DOC16/609769-2
MP06 0250 MOD 9

Review of Fern Bay Residential Subdivision - Modification 9

ATTACHMENT 1 – OEH REVIEW - PROPOSED MODIFICATION OF THE PROJECT APPROVAL FOR THE RESIDENTIAL SUBDIVISION DEVELOPMENT AT SEASIDE BOULEVARD, FERN BAY (MP06 0250 MOD9)

SCALE	1: 1000	DRAWING TITLE	STAGES 18 & 19 DETAIL PLAN REV L
REVISION DATE	01/11/2016	DEVELOPMENT	PROJECT PLAN L
PLOT DATE	01/11/2016	DRAWN/CHKD BY	FERM BAY SEASIDE VILLAGE
DA NUMBER		IMC / AED	NELSON BAY ROAD, FERN BAY
		CC NUMBER	CLIENT
			RAWSON COMMUNITIES PTY LIMITED

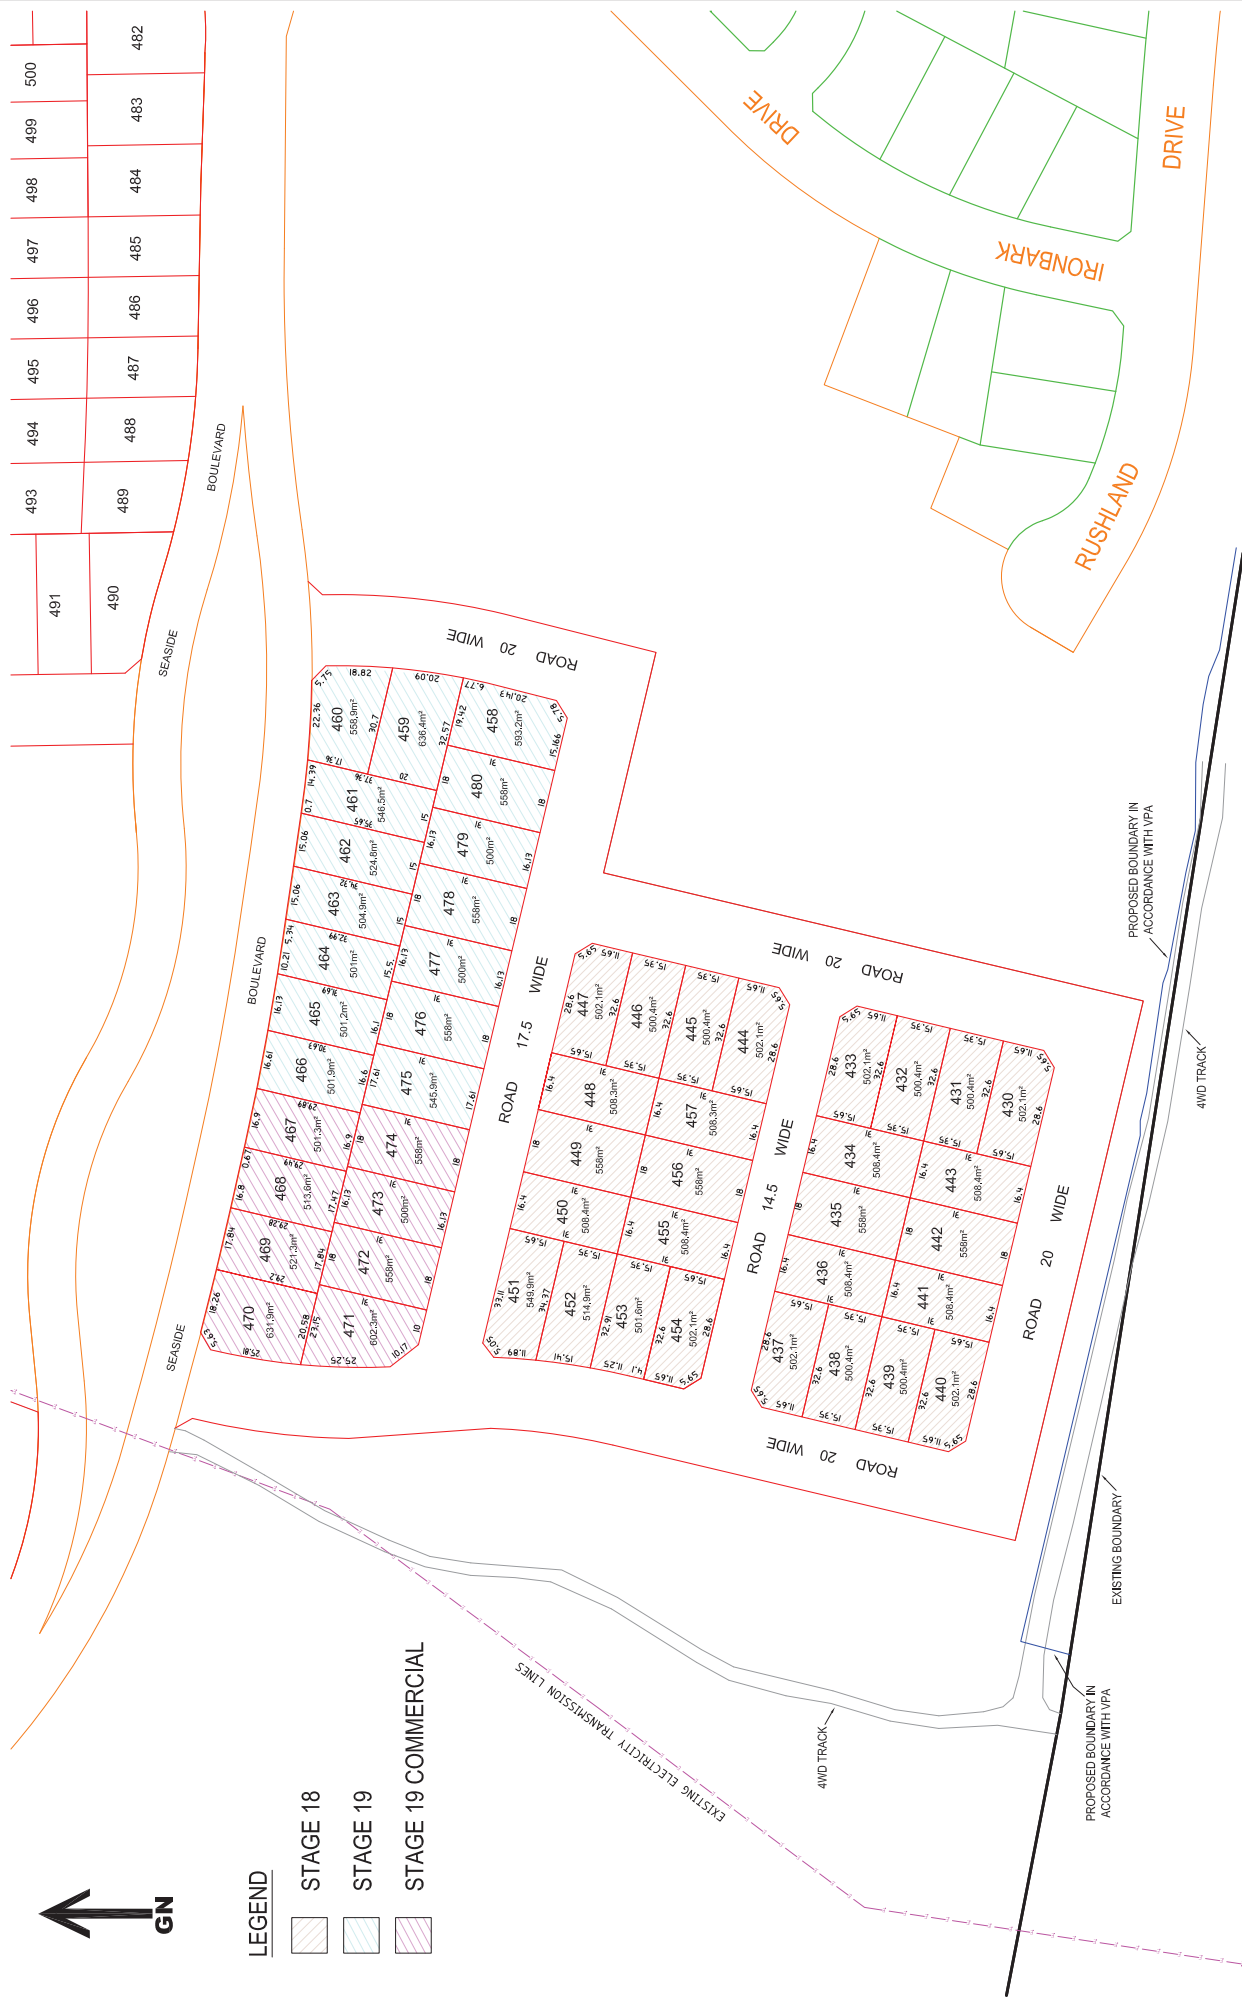
- The WCL boundary adjoining stage 18 will be adjusted, as per a VPA commitment. Whilst this is yet to occur, the proposed boundary is noted on one diagram (sheet 8 of 21, 2016-11-10 34878 PROJECT PLAN REV. L).

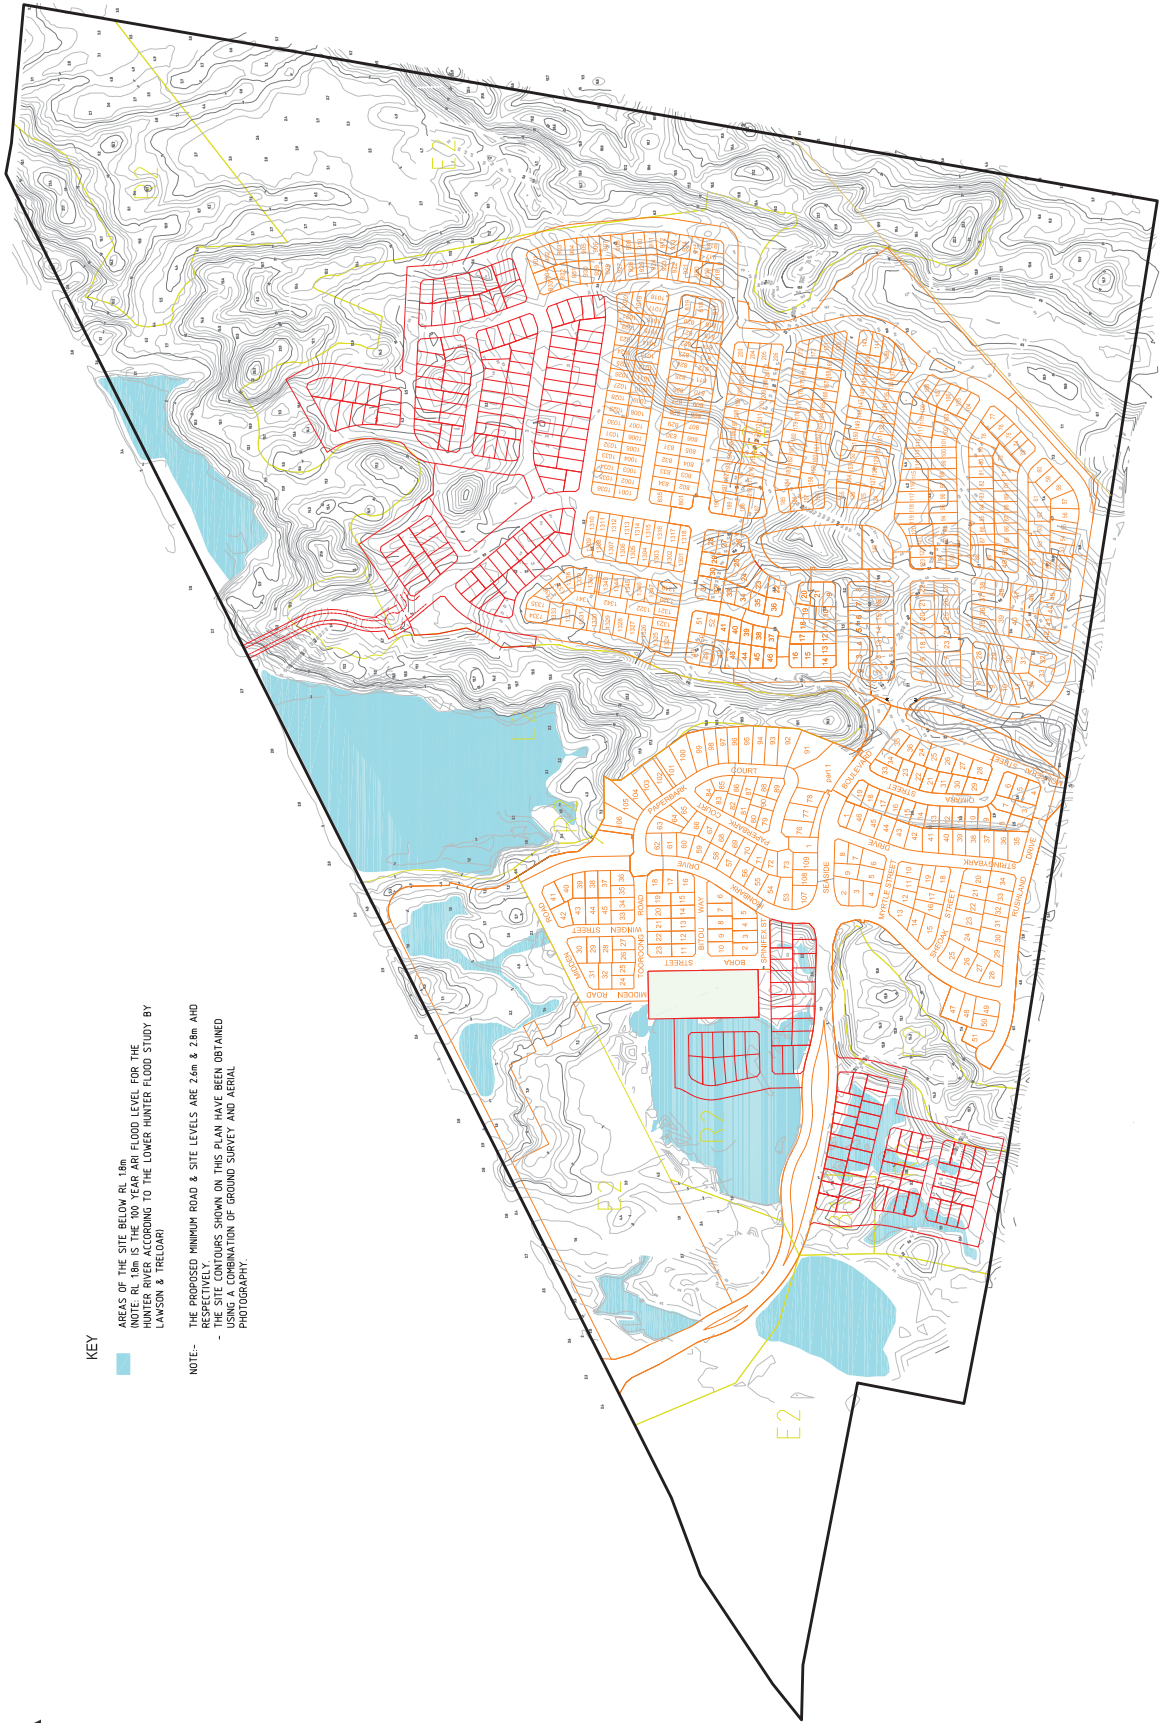
- Stormwater management from stages 18 and 19 – NPWS note the inclusion of a drainage swale (2016-11-10 34878 PROJECT PLAN REV L_2016-11-01.pdf_ Concept Site Drainage Plan page 14 of 21) and also identified as a conveyance swale/conceptual swale (2016-11-10 34878 PROJECT PLAN REV L_2016-11-01.pdf_ pages 11-23pdf page 12 of 21) (see Figure 1) extending west to link to the low-lying wetland area referred to as a detention basin. NPWS note that the proposed drainage/conveyance swale cuts across the existing 4WD track that provides access

PROPOSED RETAINING WALL

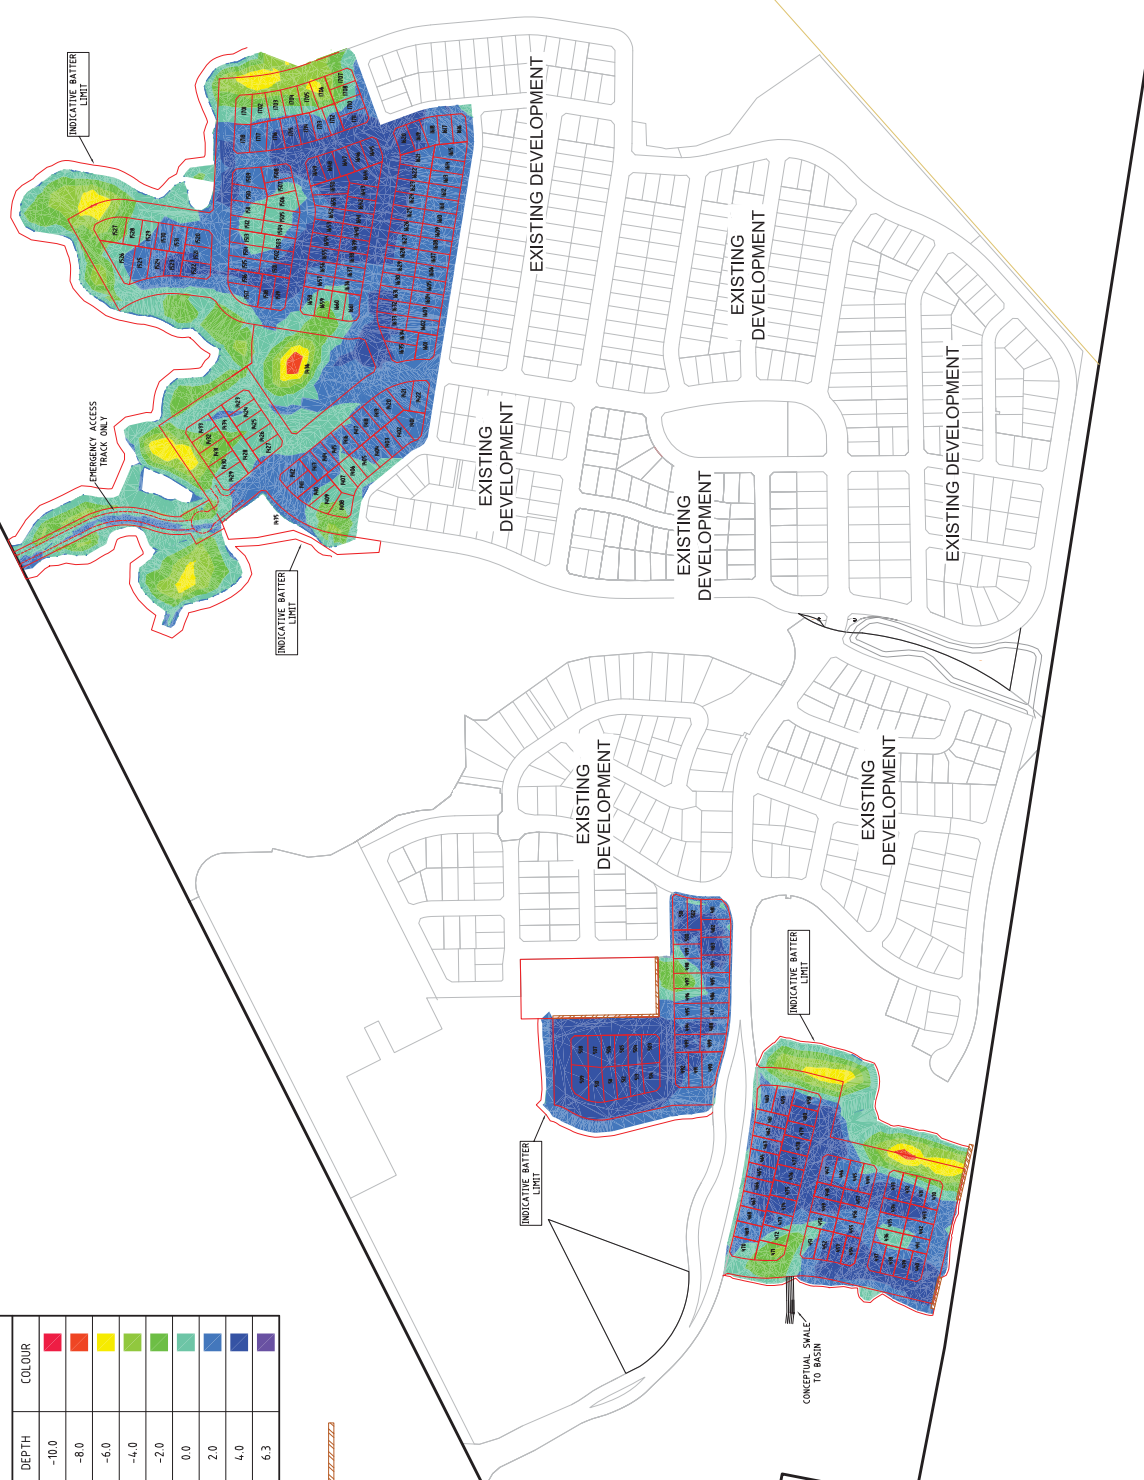
- Noting the bulk earthworks (cut-fill) diagrams, the requirement for a retaining wall to be constructed along the southern edge of stage 18 is noted. Given the closeness of the new boundary to the location of the retaining wall, NPWS are concerned to ensure the retaining wall is constructed to a standard that considers the adjoining park infrastructure – the 4WD track), and that the retaining wall is located outside of the WCL to an extent that enables any necessary maintenance and associated future works to be conducted without requiring works on the WCL, which would require approval/consent. It would be helpful to see the proposed WCL boundary shown on other diagrams in the documentation, including the bulk earthworks diagrams.
